Your Ref: OWPC17411
Our Ref: A/8/18/PL 26-01-2018
Please ask for:
Mrs A Gardner

Variation of condition 2 imposed under A/173/16/PL to read 'the development to be carried out in accordance with the following approved plans ADC 962/04 REVA, ADC962/13 & ADC962/14 relating to revised position of rooflights on east, north & south elevations. This application affects the character & appearance of the Angmering Conservation Area.

Land Rear of 1 To 6 The Cottrells Angmering

Rev	Description	Date
Job Reference New House The Cottrells Angmering, BN16 4AF		
Client AM Homes Ltd		
Drawing Title First Floor Plan & Roof Plan		Drawing No ADC962/13
Date 16.01.18	Scale 1:100	Dwg Size A3
		Plot Style ADgrey.spl
		Drawn AD
		Checked AD

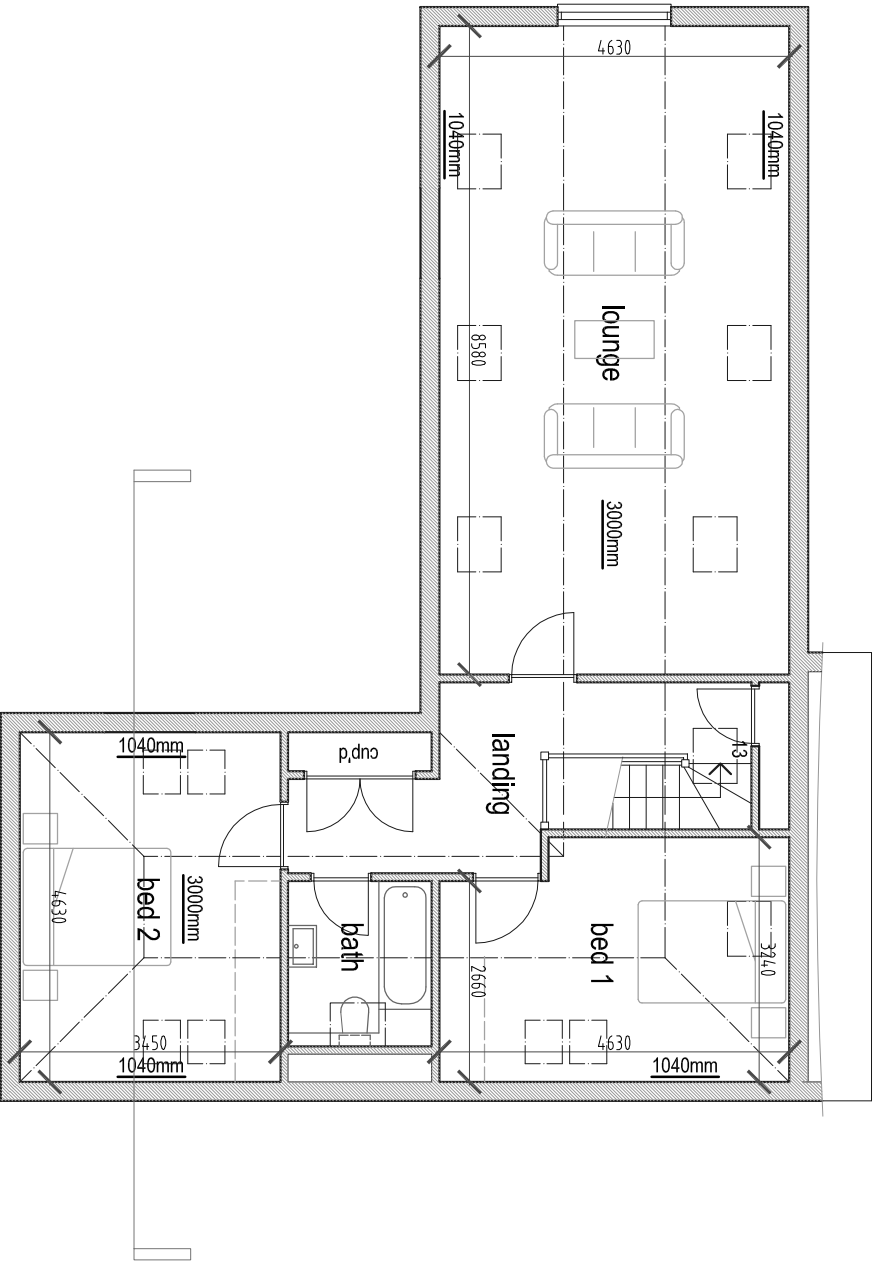
I strongly object to this application. In taking account of the proposed revisions to the first floor layout, to omit the bathroom adjacent to the living room, and the first fix plumbing that has been installed in this area, I would suggest that there is a clear intention to move the kitchen upstairs leaving the space on the ground floor free for a third bedroom. This would inevitably lead to yet another car in our road for which there is no room. There has to be consideration for the safety and well-being of the existing residents in our road. There is also the matter of both the windows and the roof shape which are being built totally different to the approved drawings in disregard to the residents of numbers 1-6
